From: [REDACTED]
Sent: 22 June 2018 16:52
To: [REDACTED]
Subject: Re: 28 Canada Grove, Bognor Regis - BR/126/18/DOC

I write to you regarding the recently submitted Discharge of Condition application for 28 Canada Grove.

SECURE BIN & CYCLE STORAGE PLAN Dr 2b

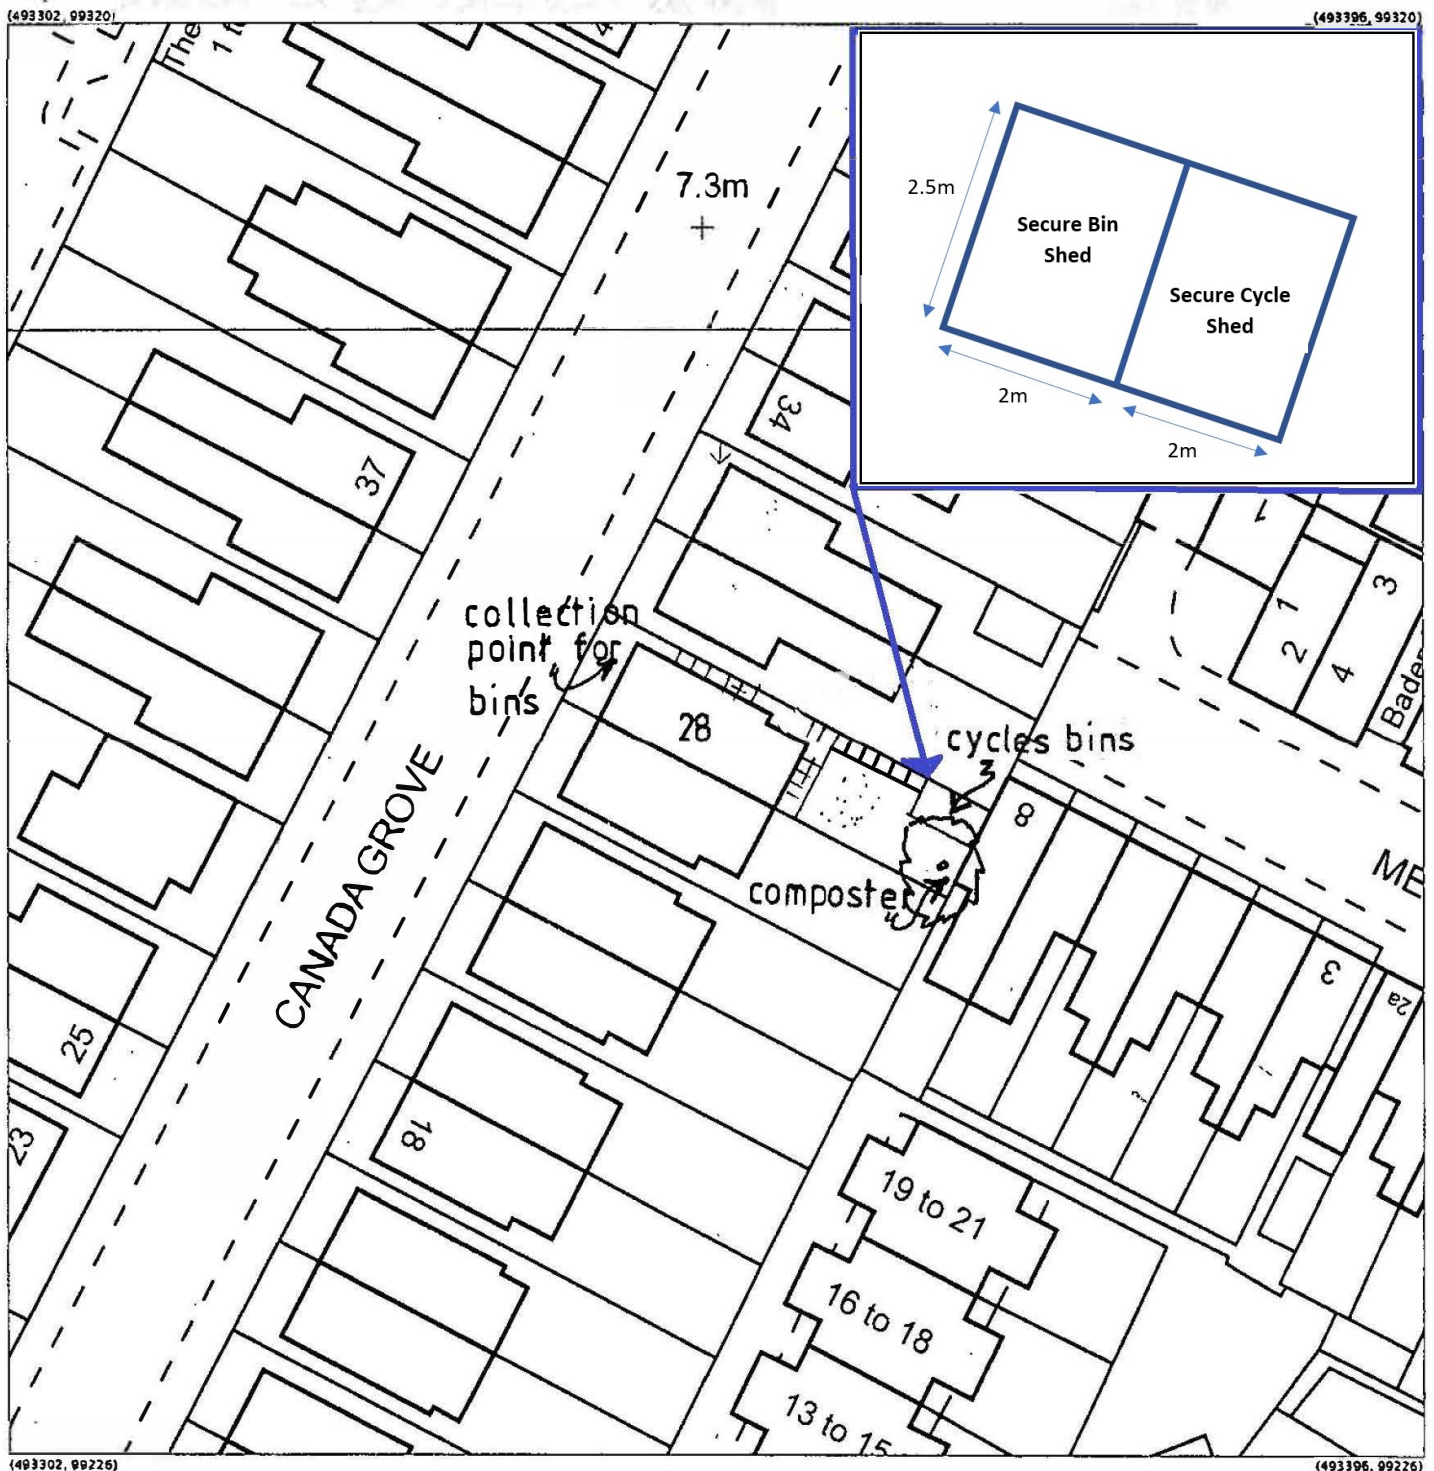
It is noted you have included details relating to the cycle storage (Condition No. 3) and as this is also outstanding did you wish for this to be added to this application?

The officer has also requested elevations of the combined bin and cycle store.

I believe the comments on the application acceptance sent by the council mention both bin and cycle storage hence the plan submitted included both but please add it if it's appropriate.

SECURE BIN & CYCLE STORAGE ELEVATION PLAN

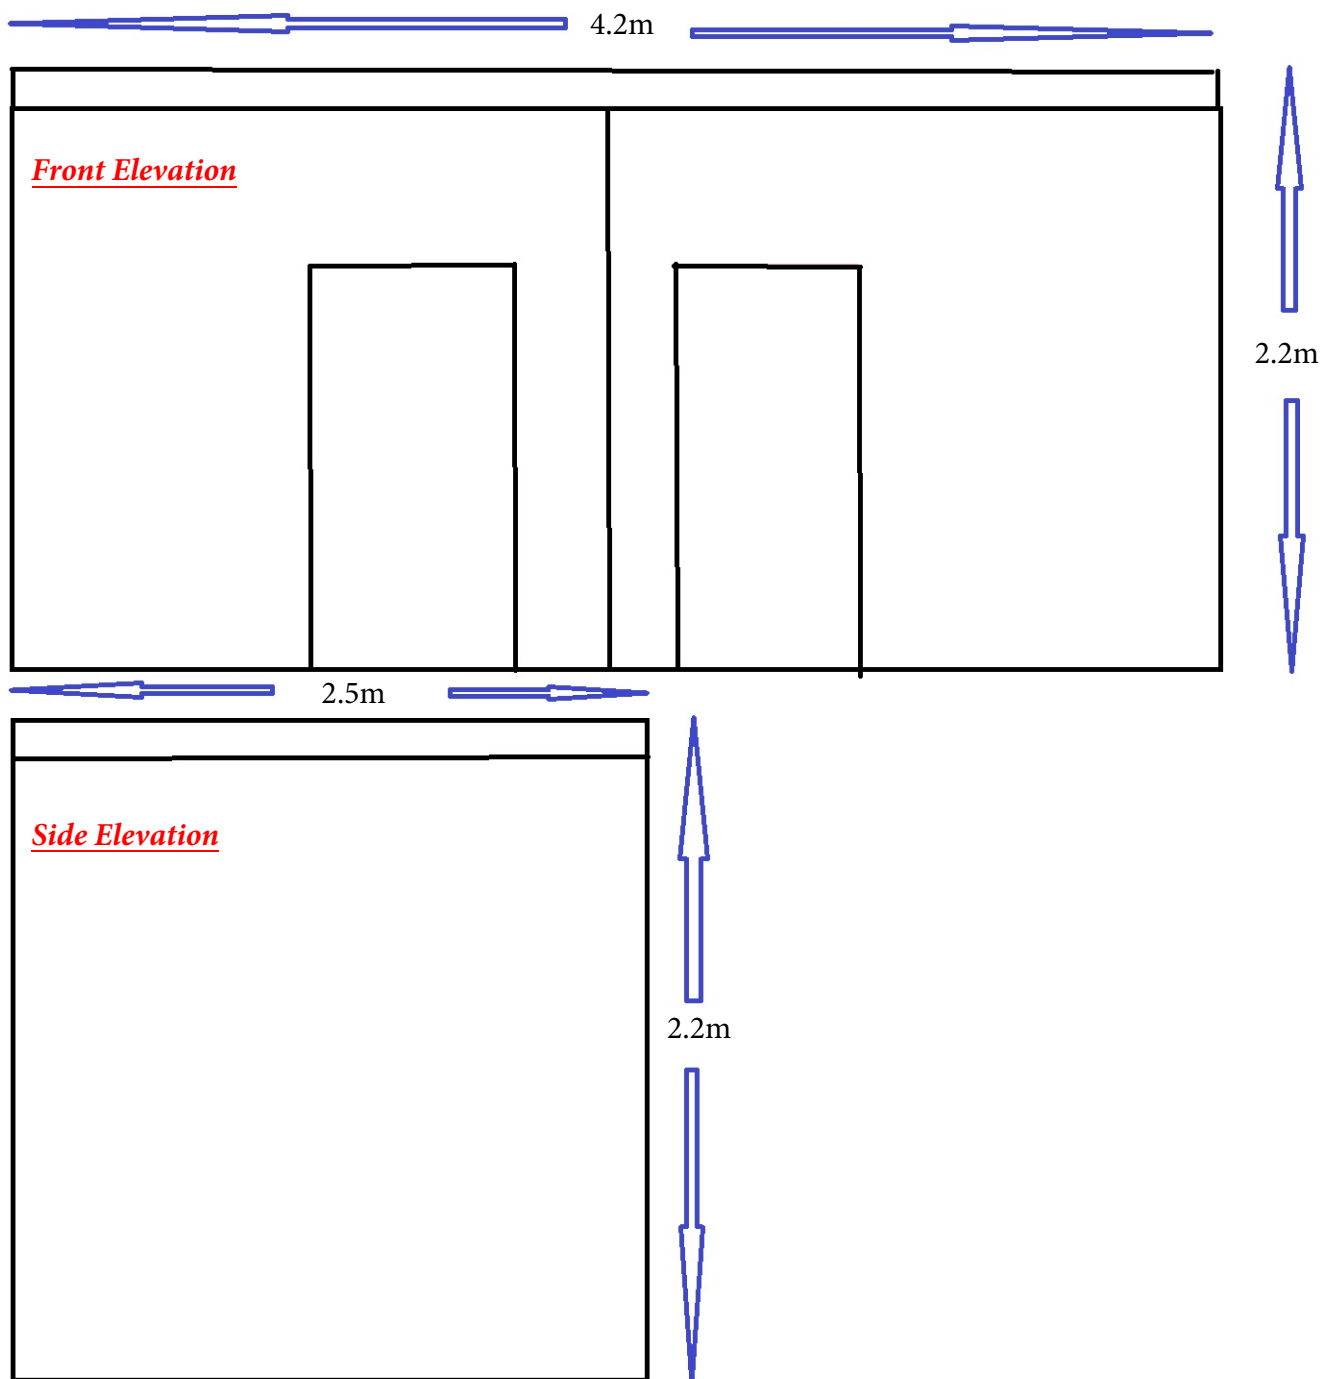
Can you provide an elevation drawing of the combined bin and cycle storage please?

Unfortunately I have still not received the elevations of the combined bin and cycle store.
